Application for a non-material amendment following a grant of planning permission.

Number	<input type="text"/>
Suffix	<input type="text"/>
Property name	<input type="text" value="2 & 4 Steeplands"/>
Address line 1	<input type="text" value="2 & 4 Steeplands and 1 & 3 Claybury"/>
Address line 2	<input type="text"/>
Address line 3	<input type="text"/>
Town/city	<input type="text" value="Bushey"/>
Postcode	<input type="text" value="WD23 1BT"/>
Description of site location must be completed if postcode is not known:	
Easting (x)	<input type="text" value="513819"/>
Northing (y)	<input type="text" value="194800"/>
Description	<input type="text"/>

The proposals are for a new build development to include 24 flats within 3 blocks over part 3 and part 4 storeys with associated car parking proposed at new basement level.

Reference number:	<input type="text" value="Ref 16/0127/FUL"/>
Date of decision	<input type="text" value="29/06/2017"/>

Drawing:  
**Proposed Elevations Block A,  
B & C**

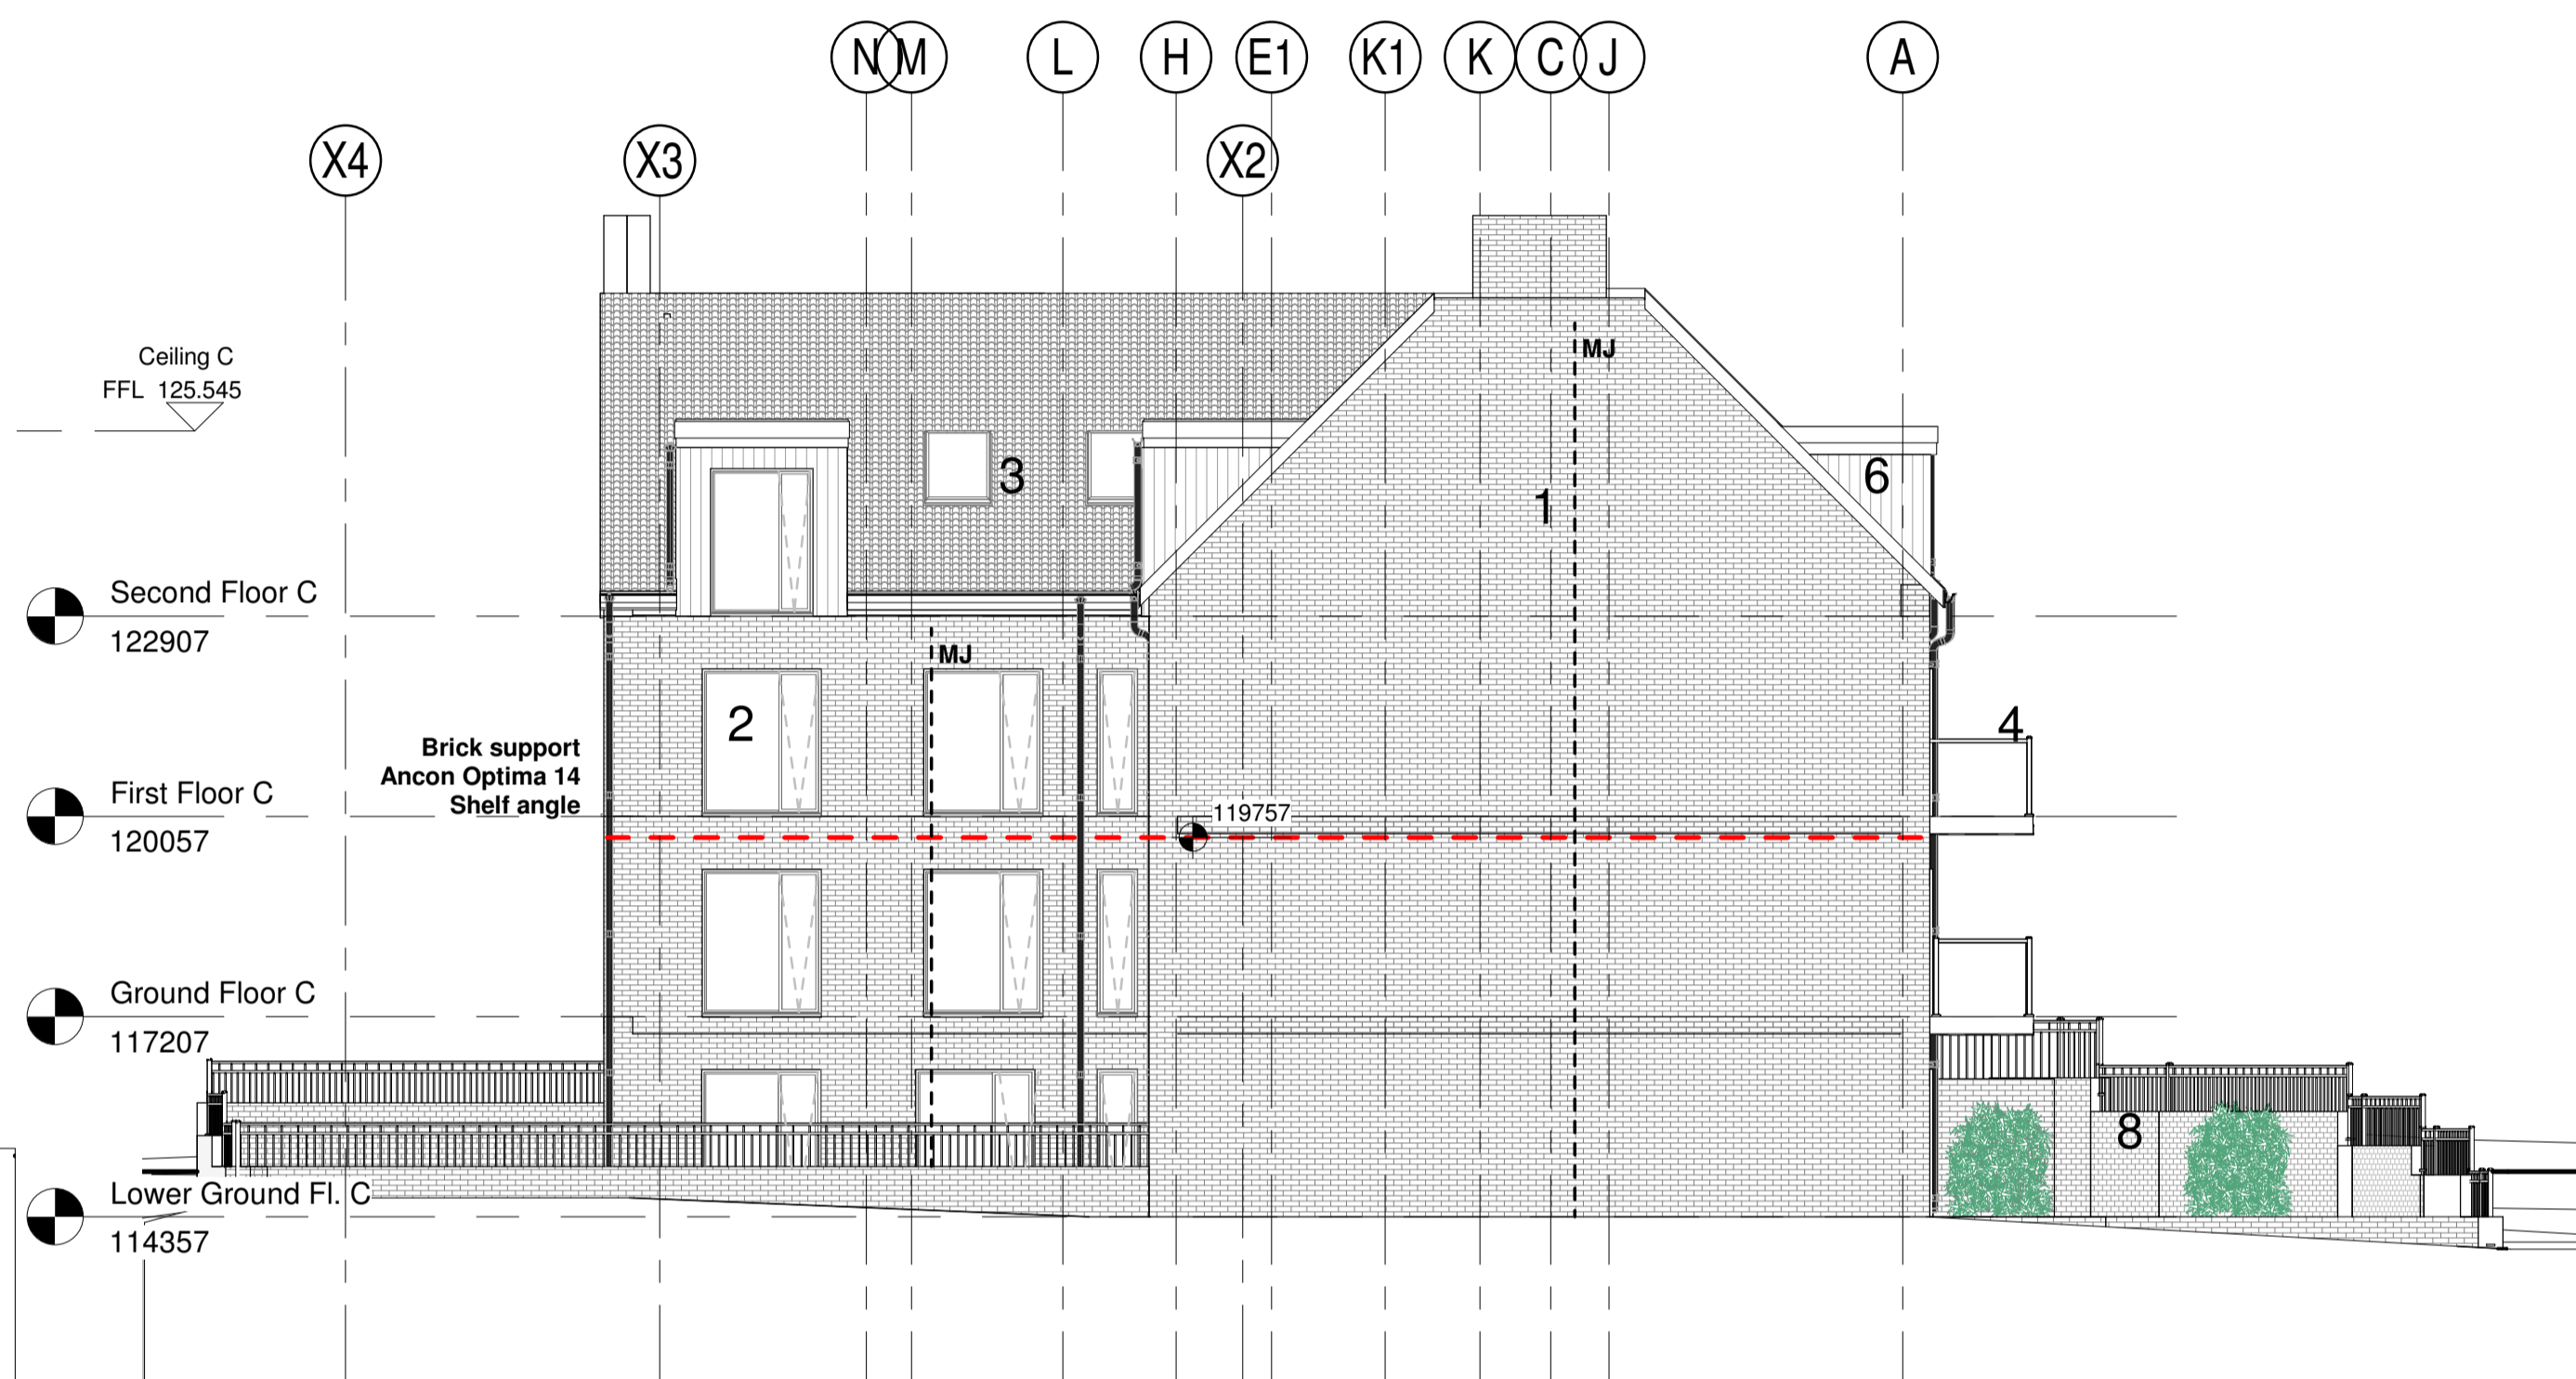
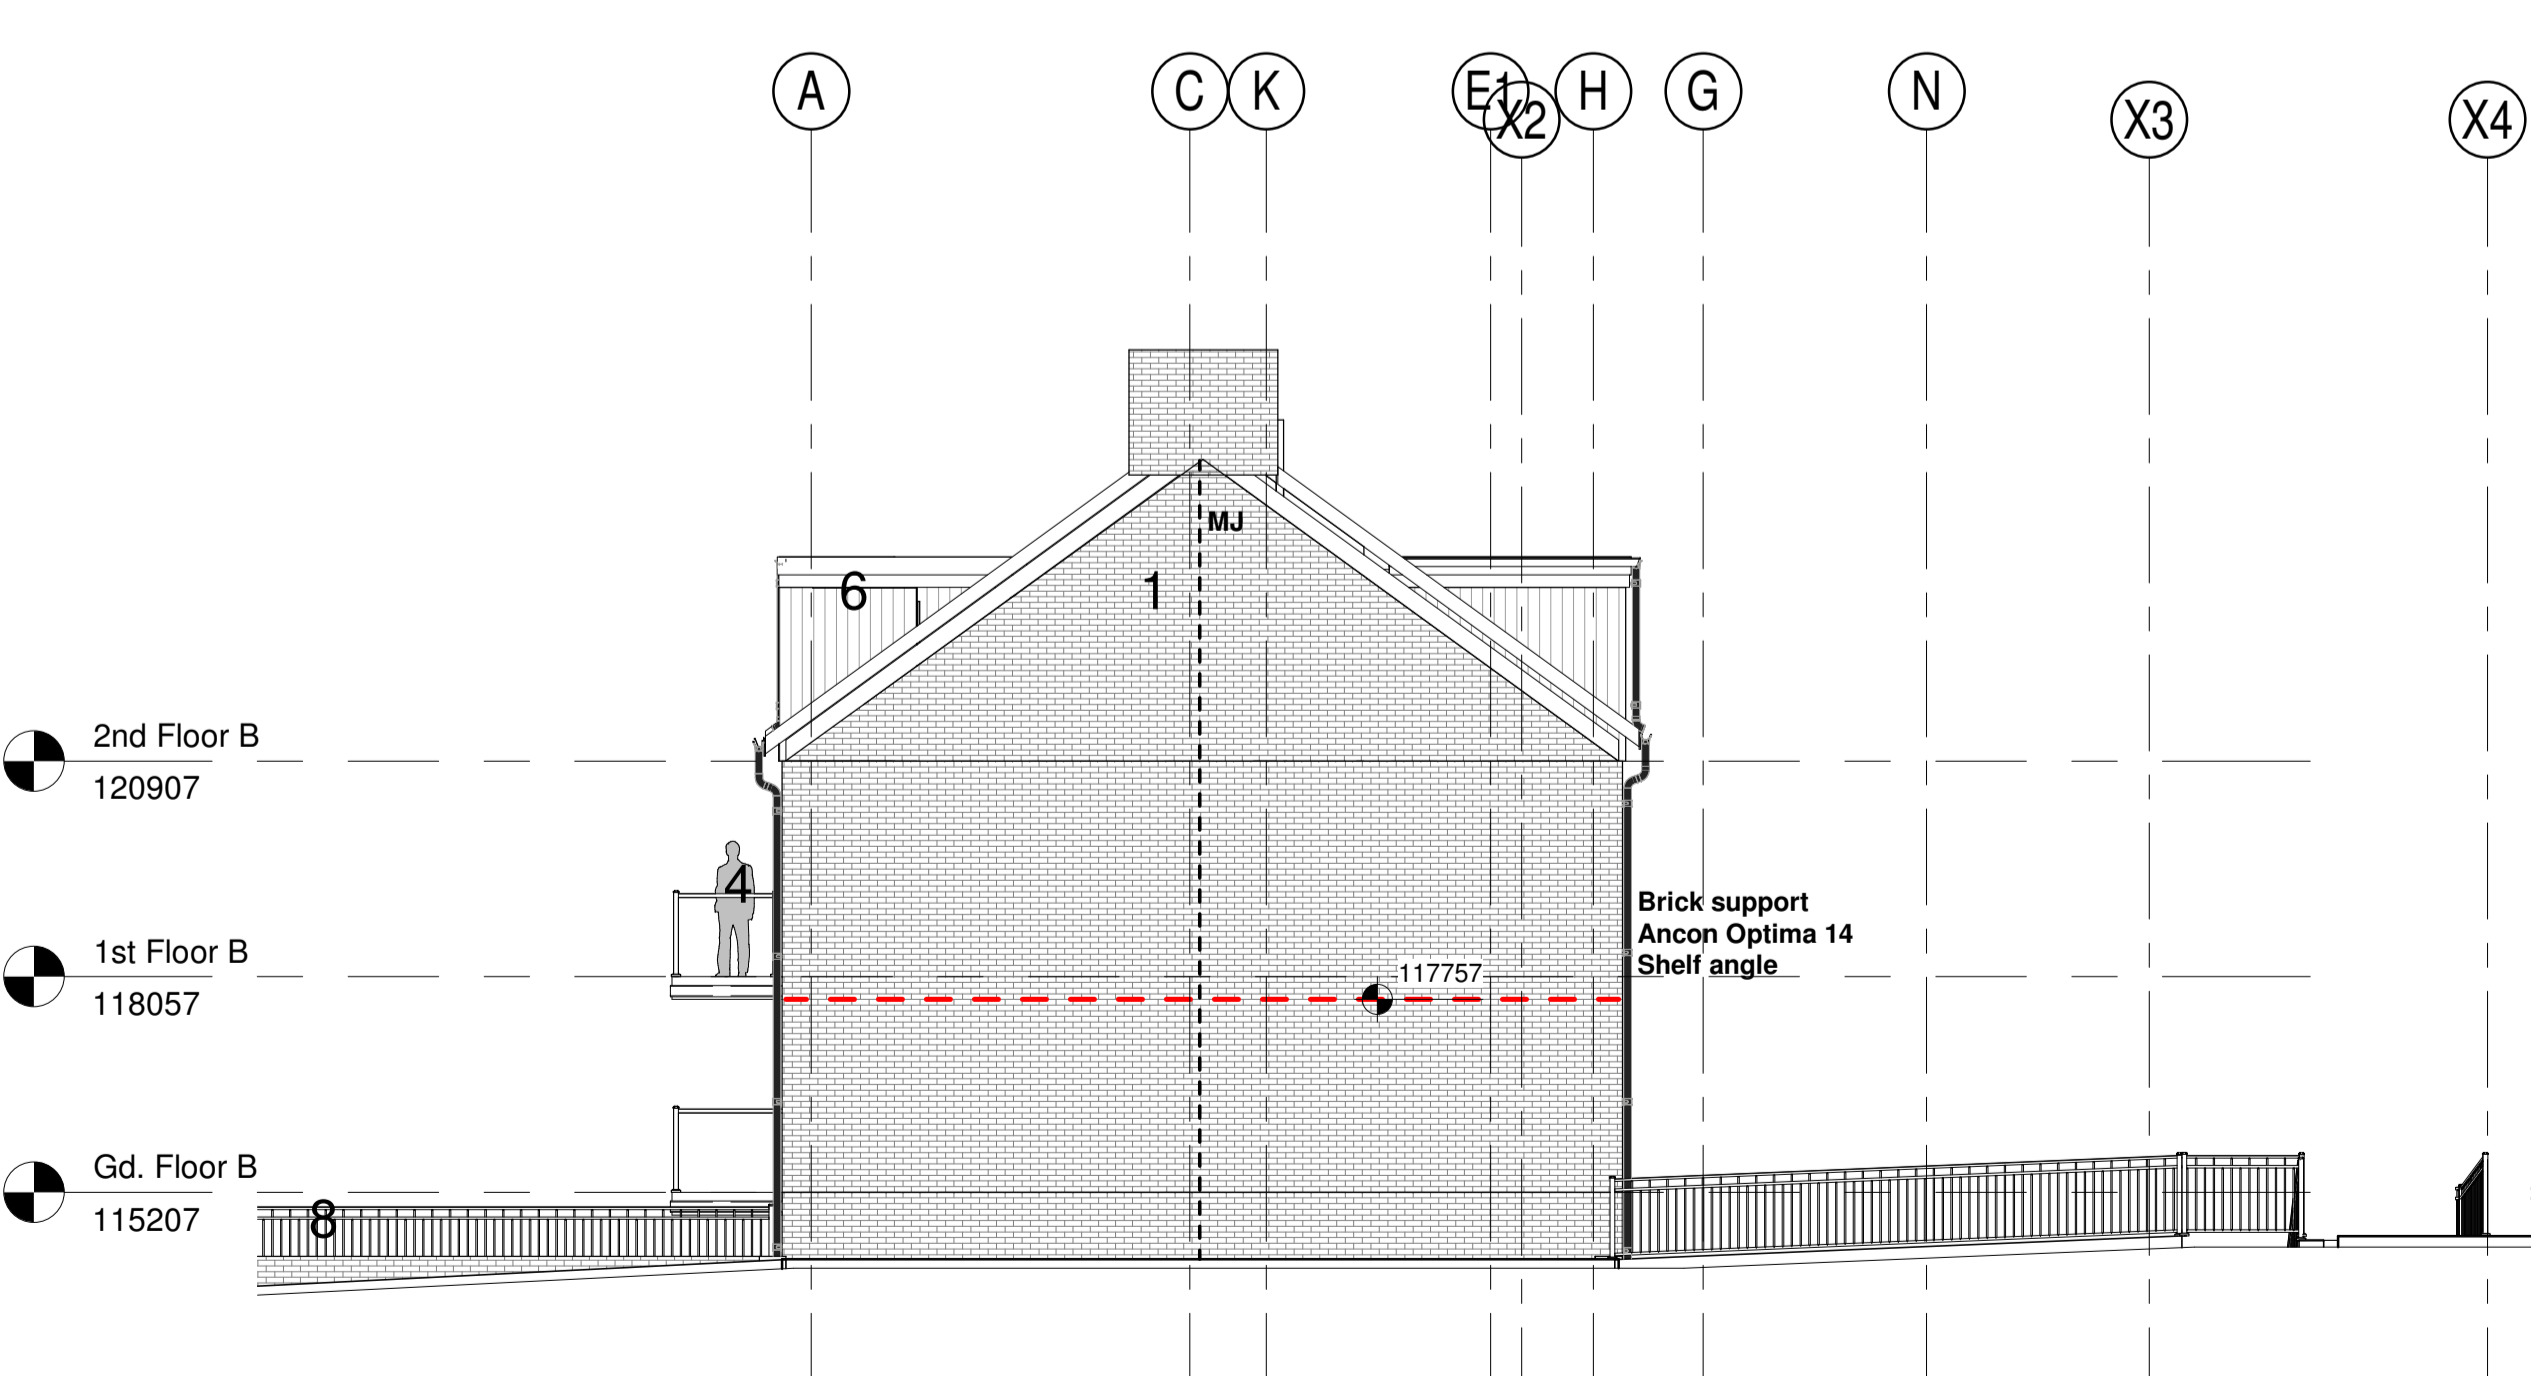
This application seeks to change the window material from timber to aluminium.

Current market conditions have resulted in excessively long procurement times for timber windows which cannot be accommodated within the construction programme for the development. Therefore we are proposing aluminium windows instead of timber, which will match with other aluminium elements that are already part of the scheme (curtain walling, balcony cladding, balustrade handrails).
